Ribble Valley Borough Council

App no: 25.0486

**Address: Land at former Higher Standen Farm (adj Swardean Way Valley Lane
Higher Peak Crescent South Gate Broadfield Street) Pendle Road
Clitheroe**

**Proposal: Approval of details reserved by conditions 3 (external materials), 8
(visibility splays), 13 (flood risk assessment), 10 (cycle storage plan)
and 16 (verification of SW drainage system) of planning permission
3/2023/0305.**

client: eric wright construction
project: proposed care home, clitheroe
project number: J328959
scale: 1:250@A3
drawing title:
access visibility splay
drawing number:
J32-8959-PS-001

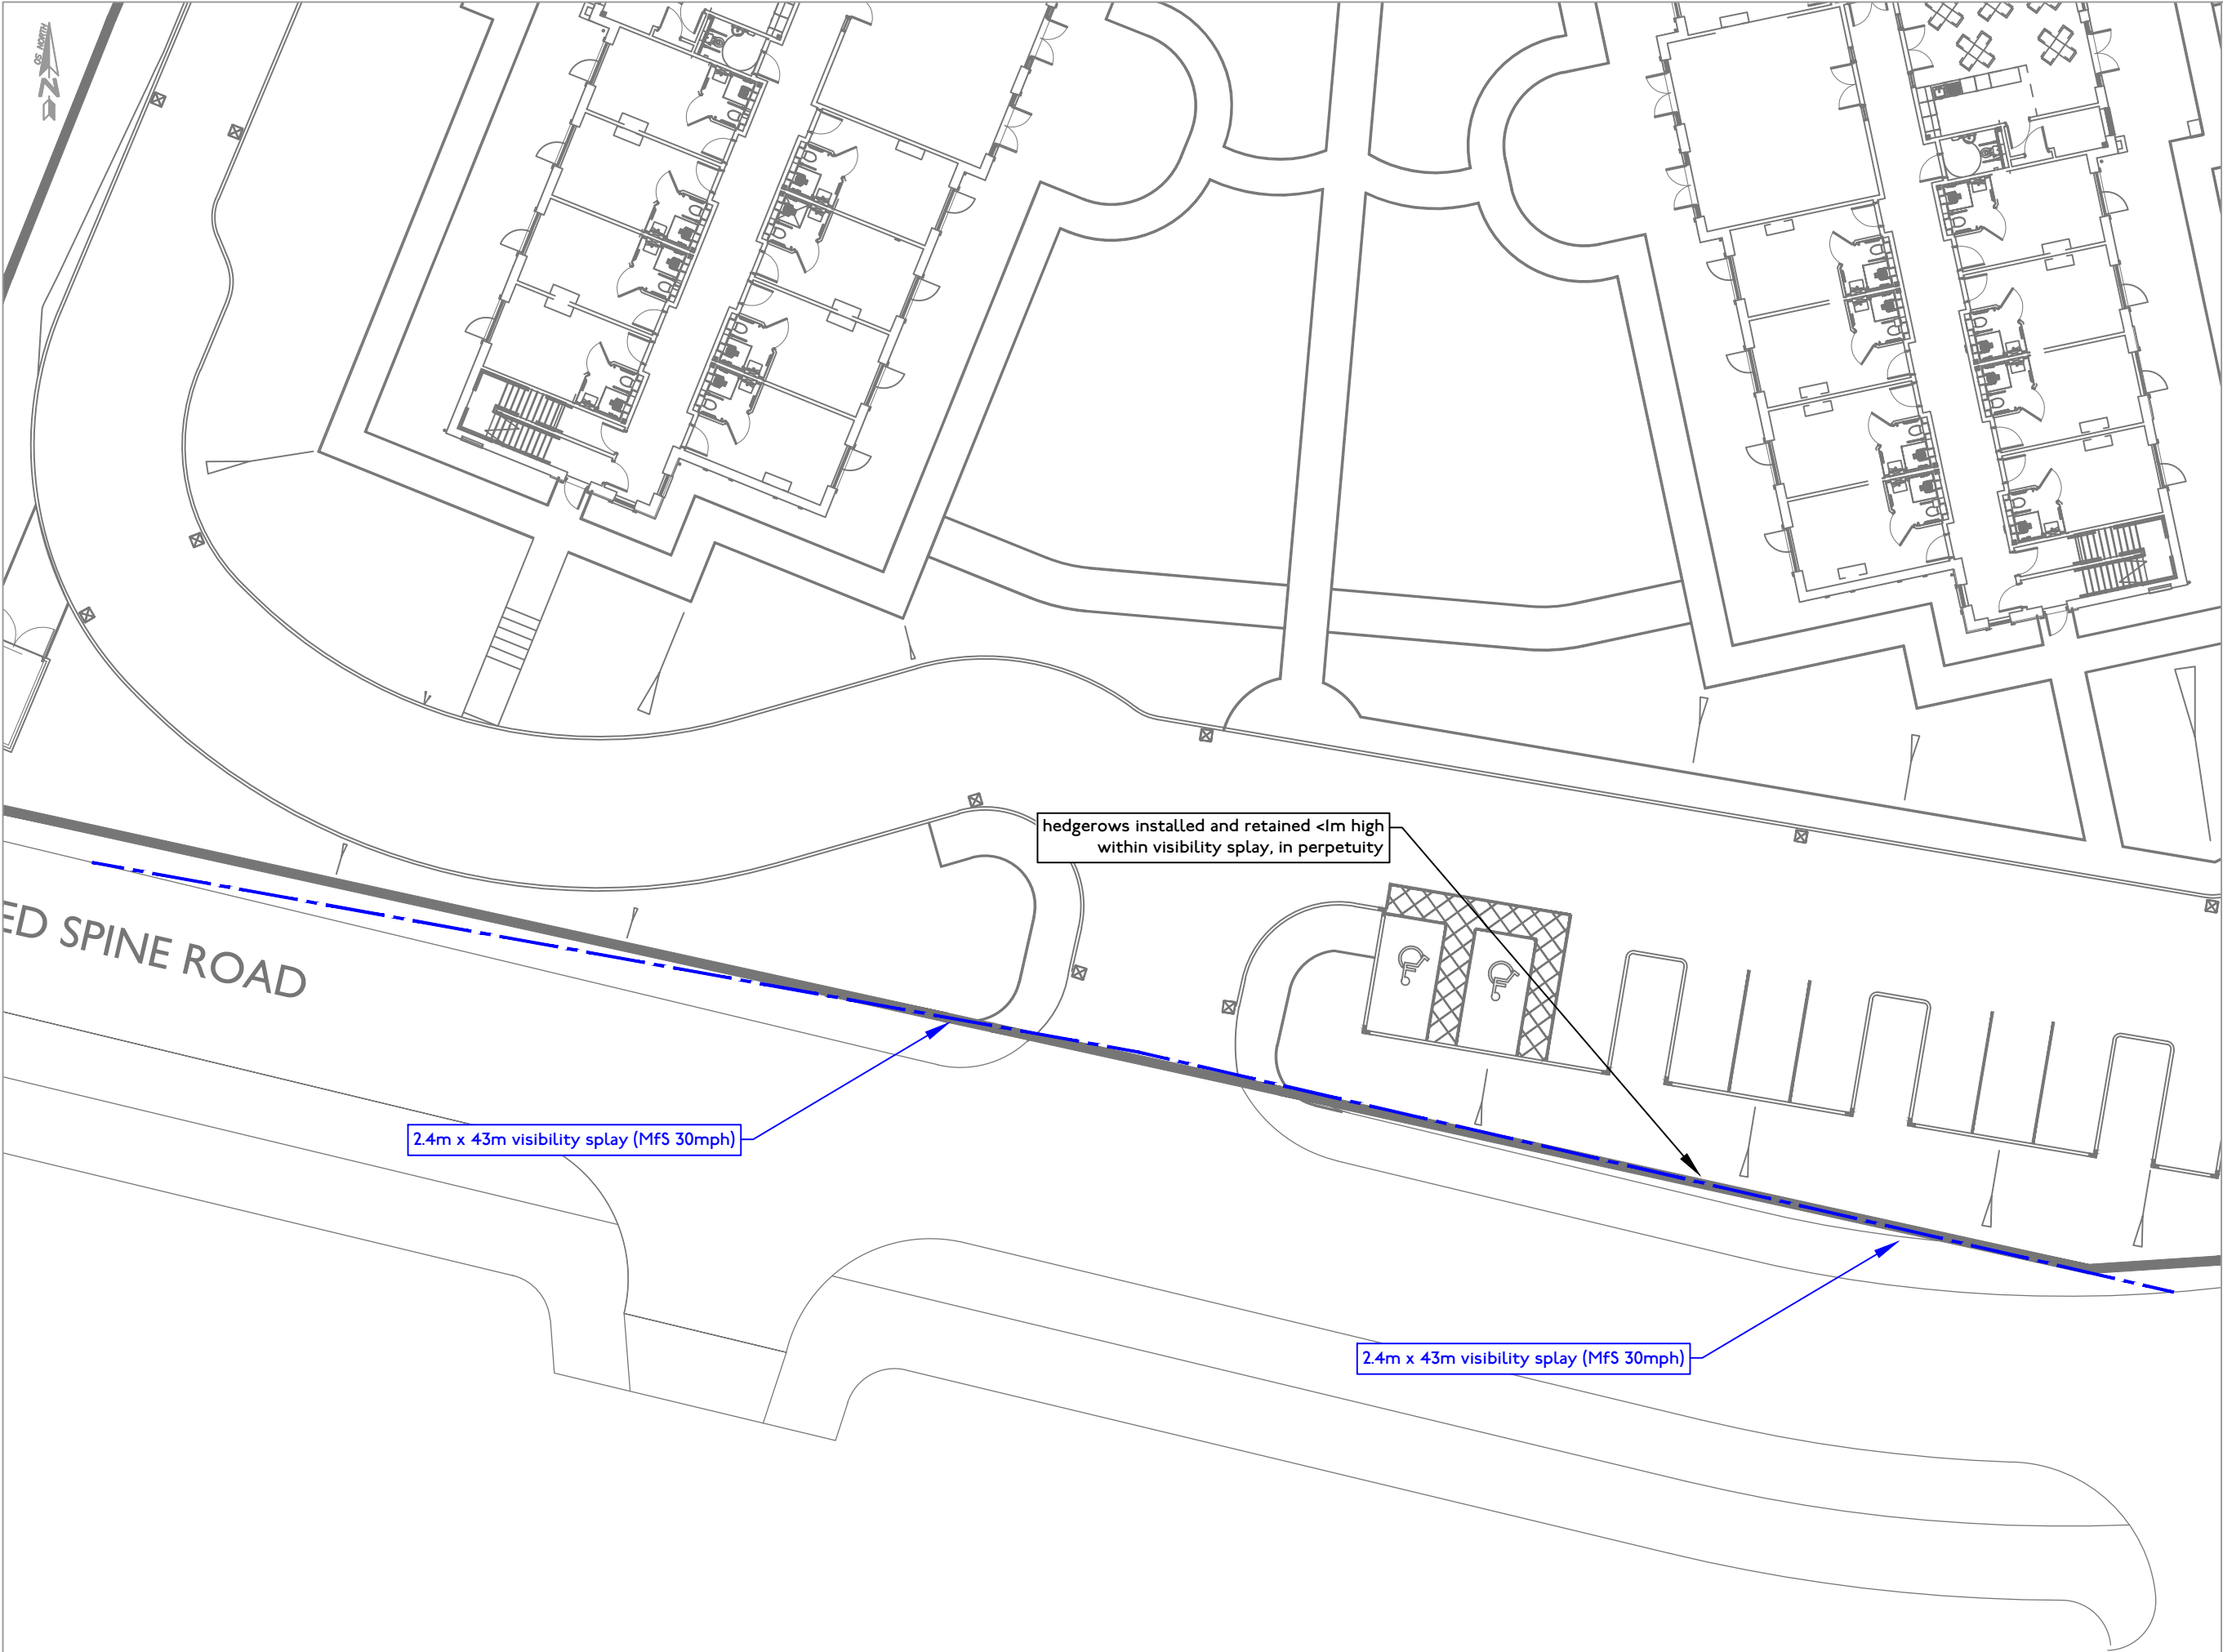
The submitted drawing 'Mode Transport J32-8959-PS-001' shows splays of 2.4m by 43m to both sides of the site access. The speed limit on the estate road is 20mph therefore splays of 2.4m by 25m to both sides are specified in the condition. Therefore the drawing shows an overprovision.
